Comments on the Applicant's Response to Deadline 6 Submissions [part 8 - Residents Businesses] by Wiliam David Moore

NMP4

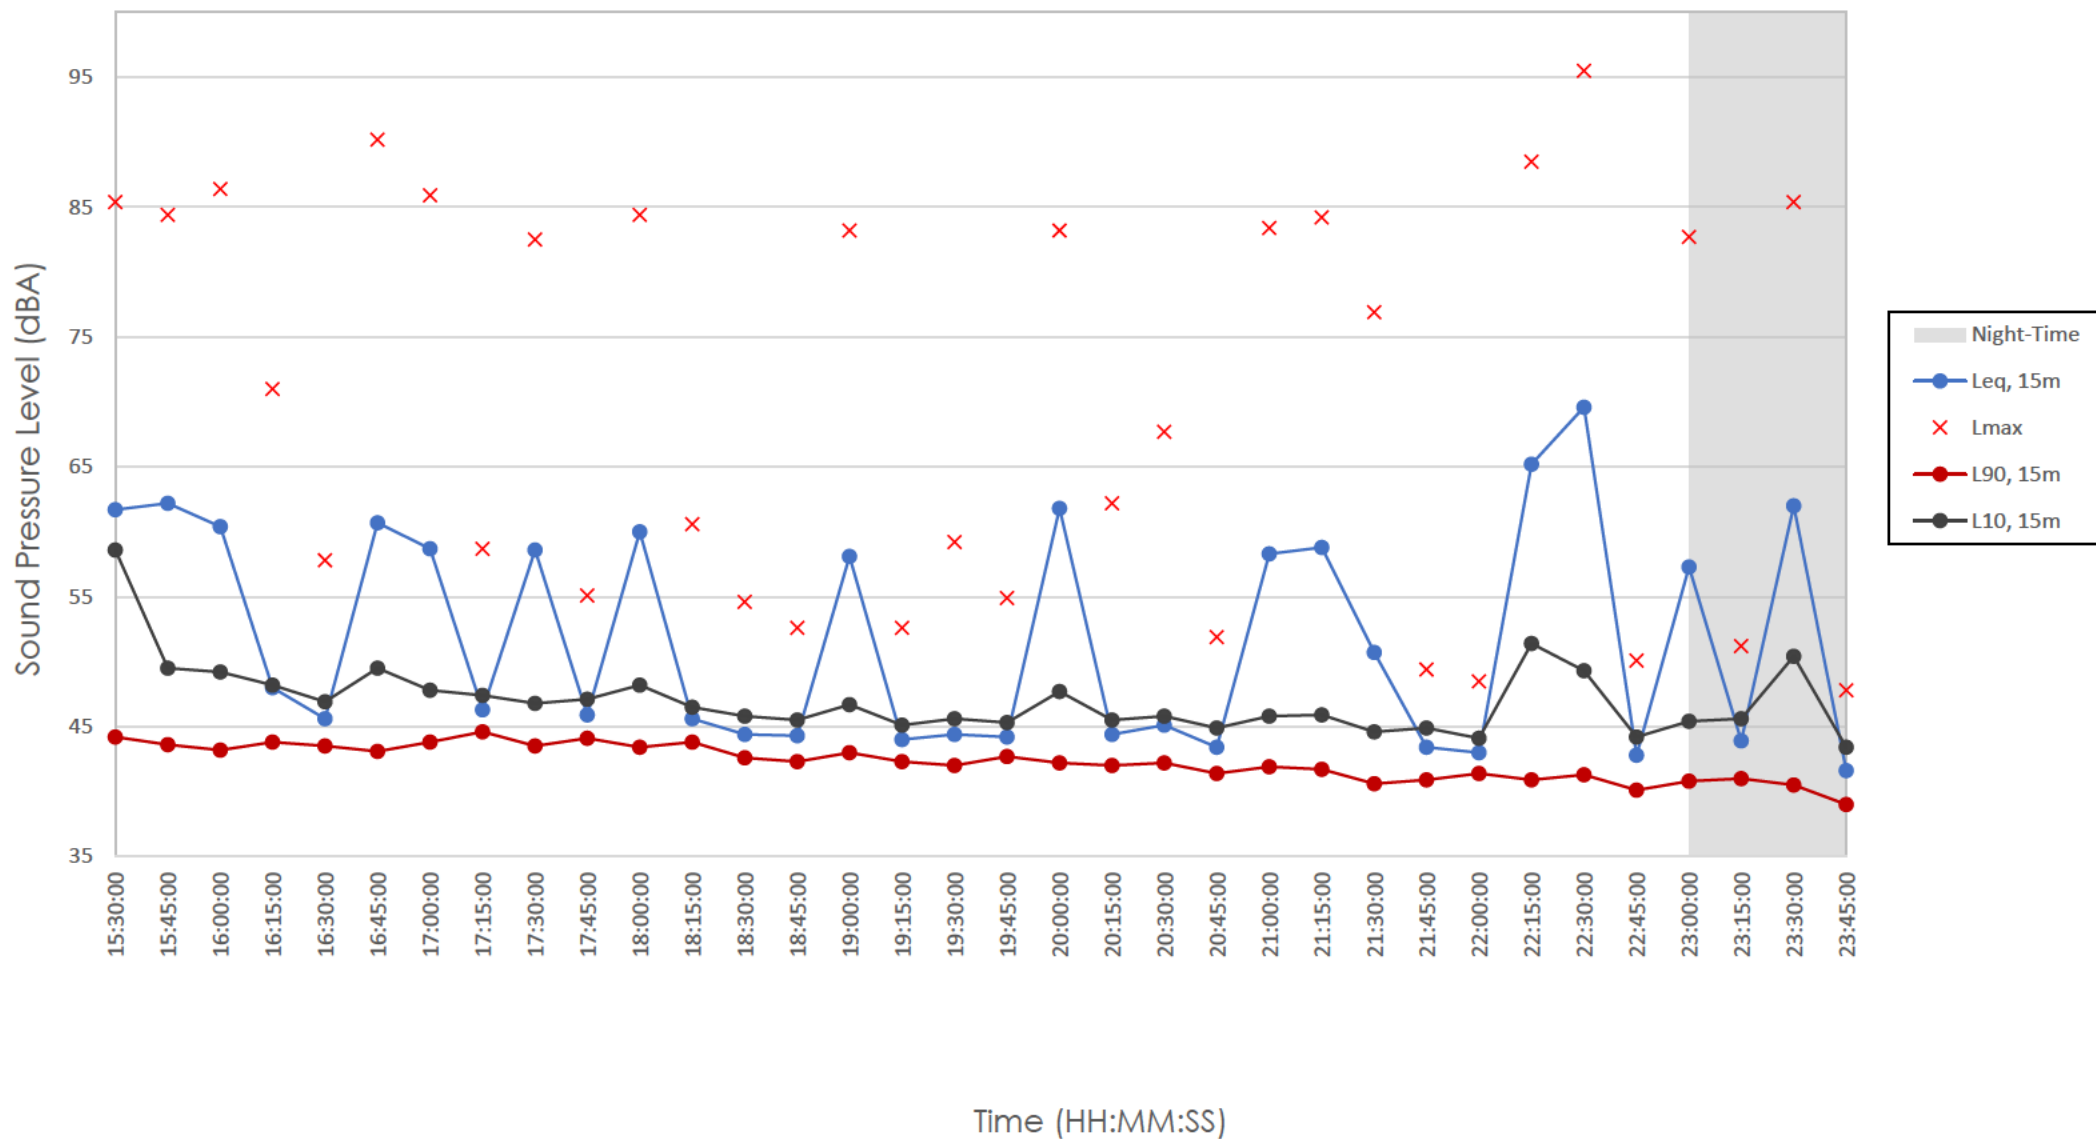
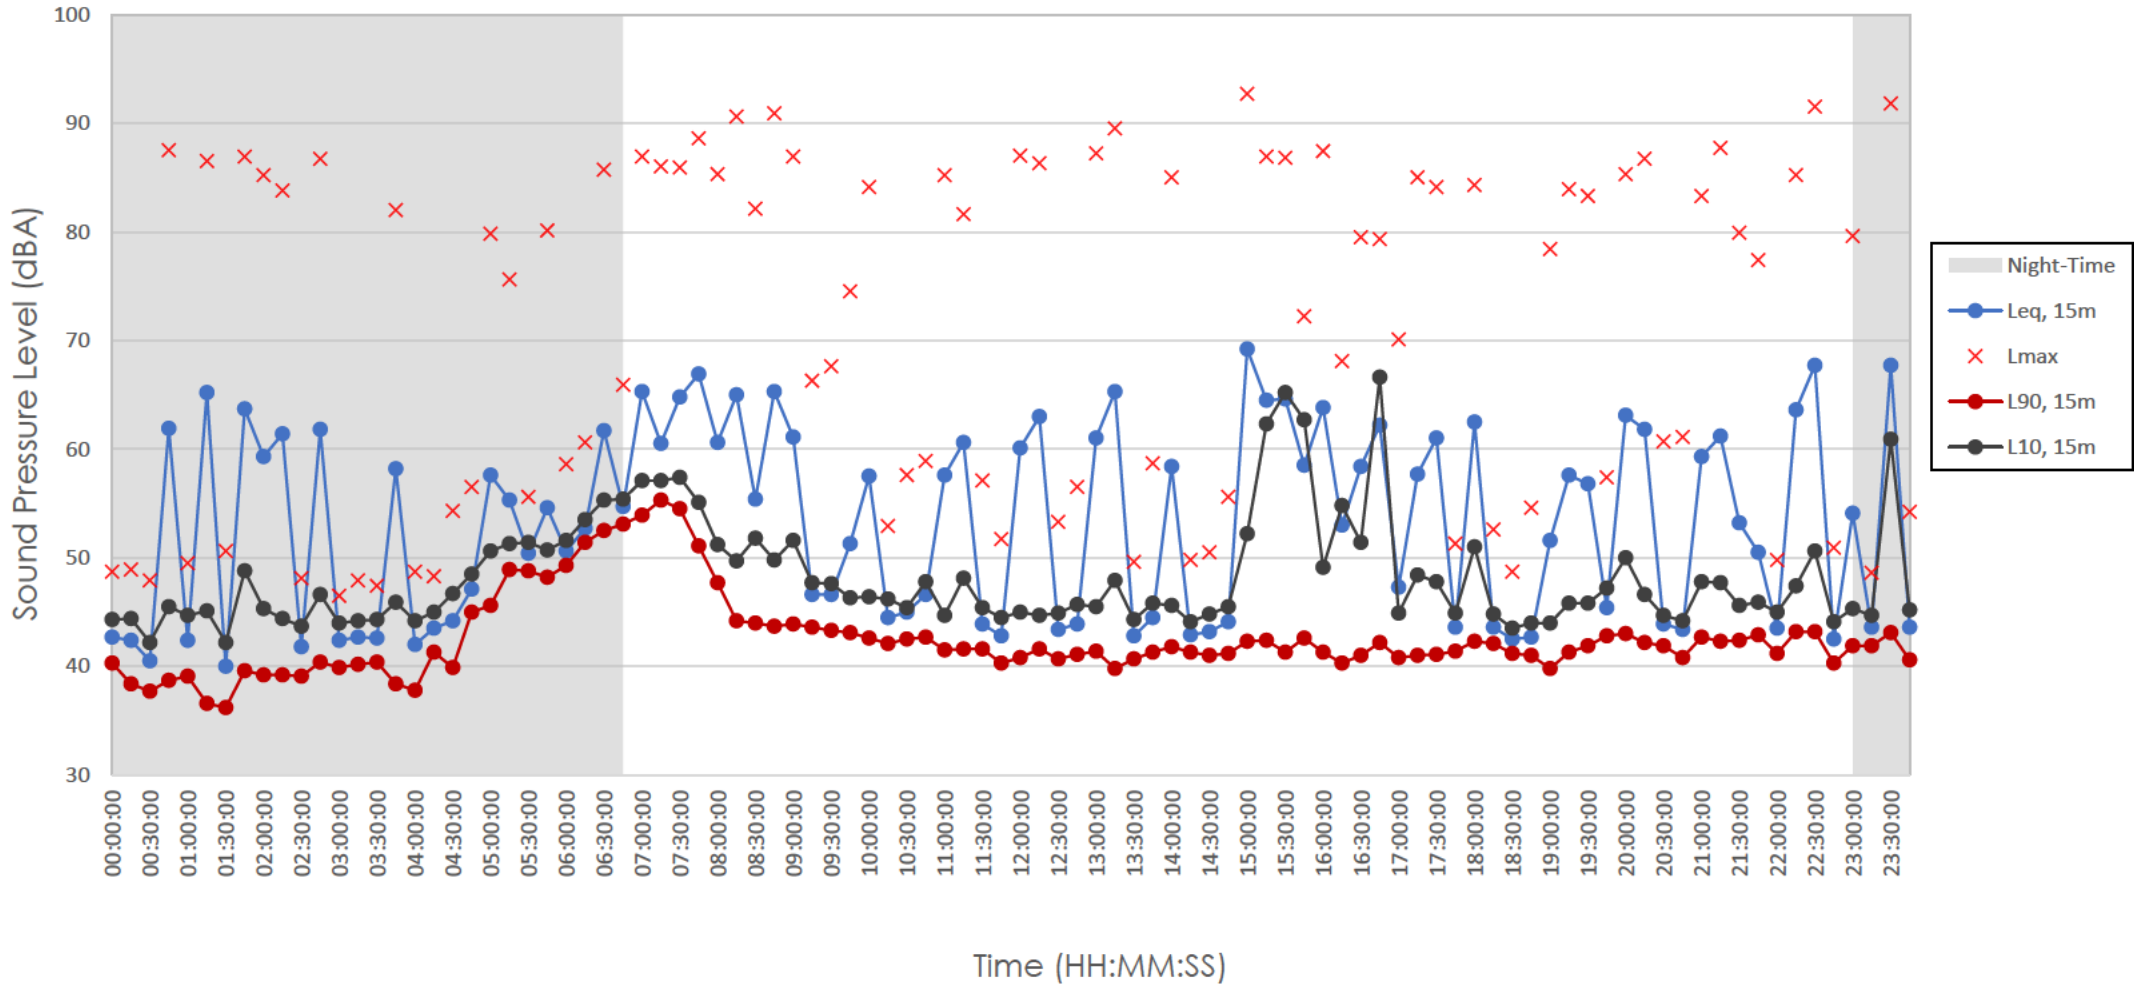
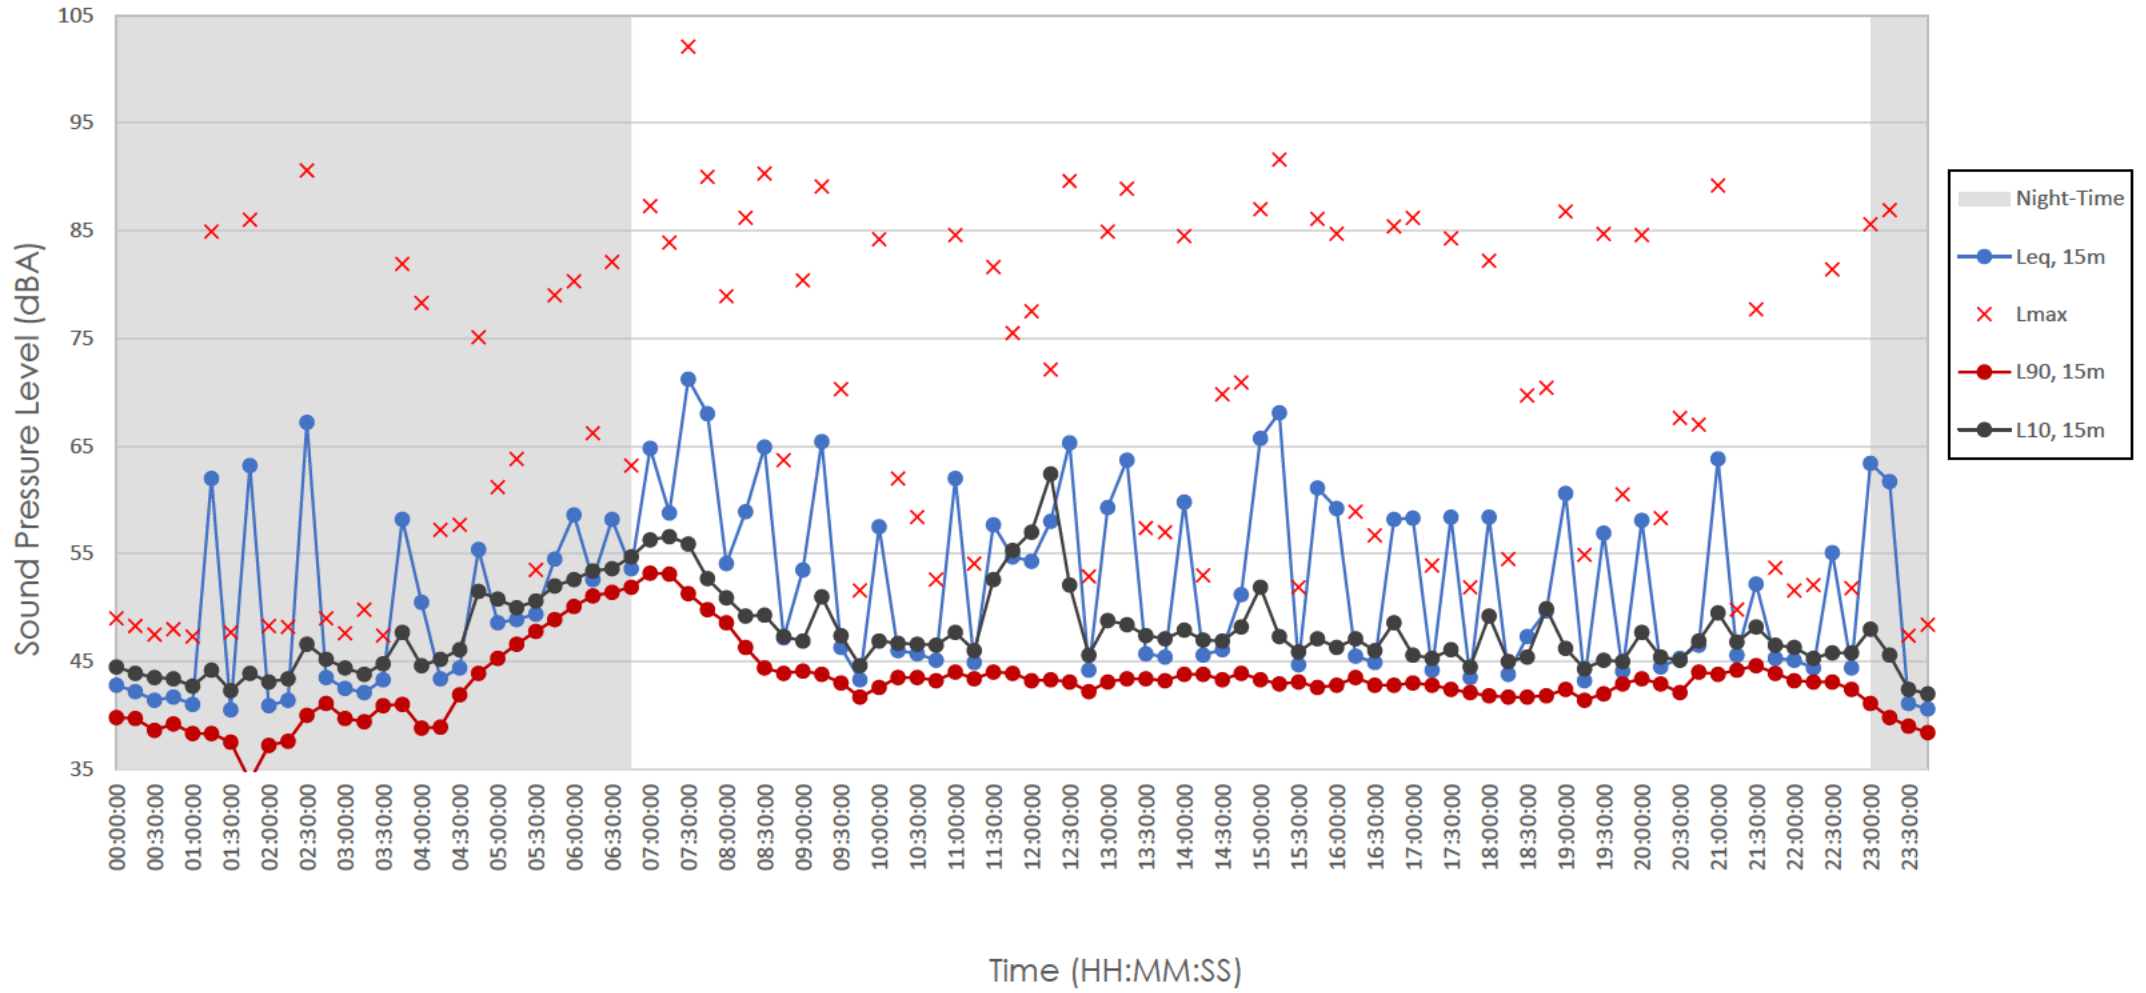
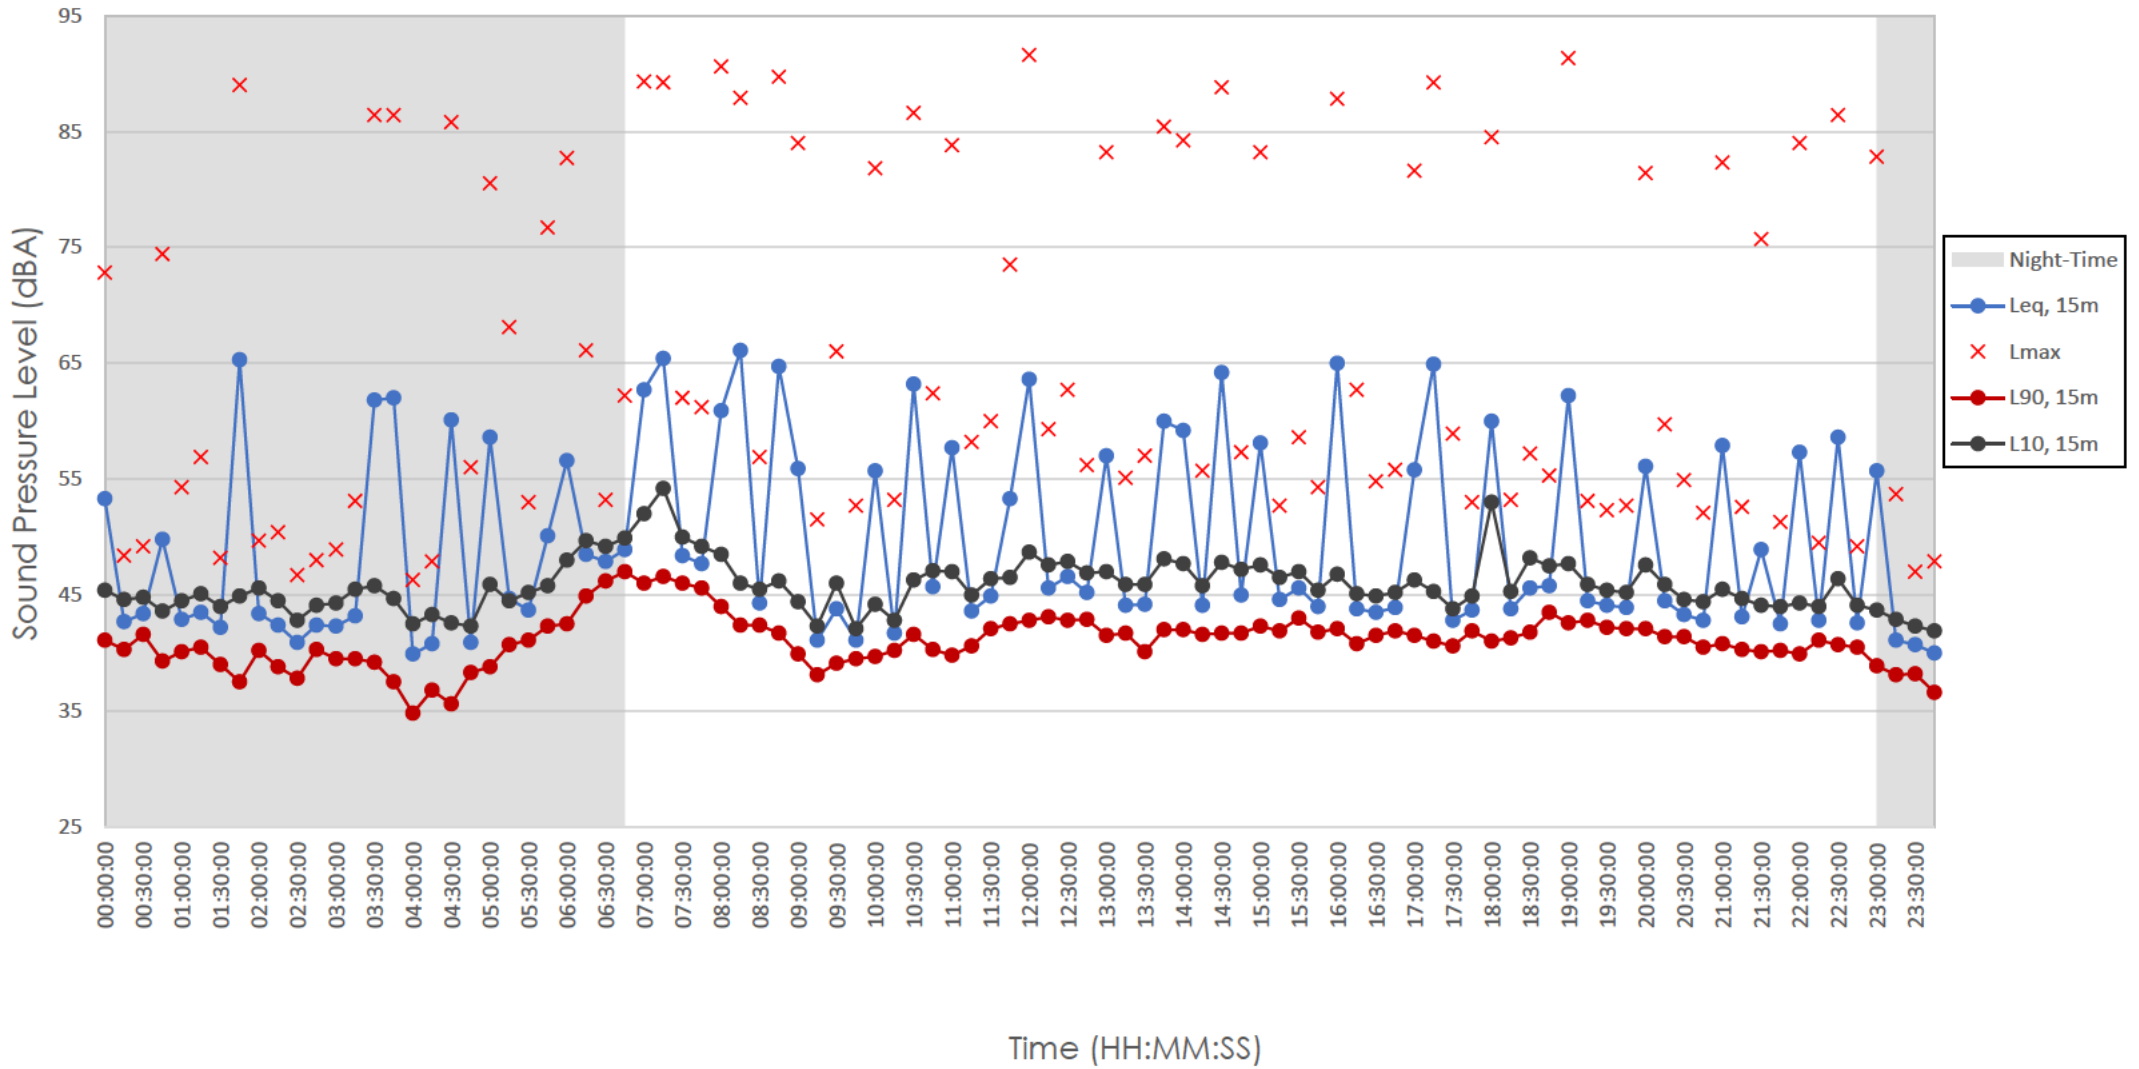
1. The applicant's noise assessment update note doesn't address all the NSRs associated with NMP4.

The applicant has started attributing the same contour claims from Billington Road East to NSR 1.

Look at the location of NSR 1 on [the applicant's road noise contour map](#). It's in the applicant's 45.0-49.9 **LA10 18hr** road noise contour. Yet the applicant is attempting to attribute 55 dB LAeq of daytime road noise to the NSR.

Like all the NSRs in the applicant's Update Note, NSR 1 is outside the applicant's rail noise contours, yet the applicant is still attempting to attribute 50 dB of rail noise to the NSR during all time periods.

The applicant's claim that NSRs experience more ambient road noise than NMP4, and therefore the sound of train pass bys measured by NMP4 during different time periods shouldn't be attenuated, is demonstrably inapplicable to NSR 1. NSR 1 is located in a **lower** road noise contour than NMP4.

It is assumed that this refers to the resultant noise levels at NSRs 1 and 24 which are now shown below

NSR	Daytime (0700-2300)				Night-time (2300-0700)			
	Rating Level	Ambient Level	Rating + Ambient	Increase	Rating Level	Ambient Level	Rating + Ambient	Increase
1	47	56.2	56.7	+0.5	47	54.8	55.5	+0.2
24	50	56.2	57.1	+0.9	47	54.8	55.5	+0.2

The reasoning already provided for the use of ambient noise levels measured at NMP4 is also applicable to NSRs 1 and 24
